Online Comment

Application H16-0561-25
Location 6-7 Hall Place Spalding PE11 1SA
Proposal Proposed Signage

FRONT FACIA

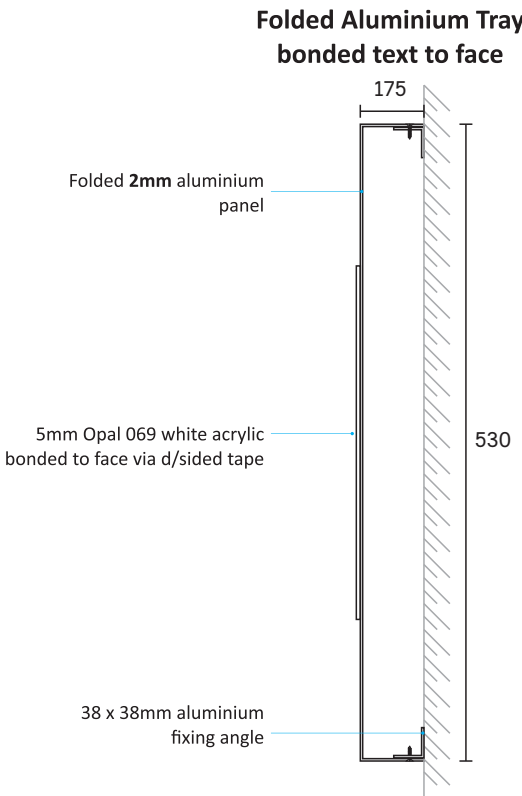
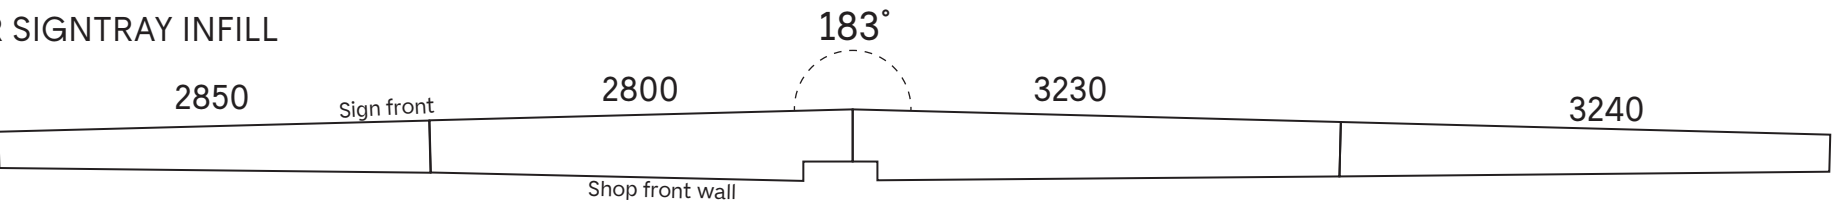
Whilst it is regrettable that a long established brand name is disappearing from the High Street, the style of the new branding is consistent with the W H Smith branding and therefore acceptable.
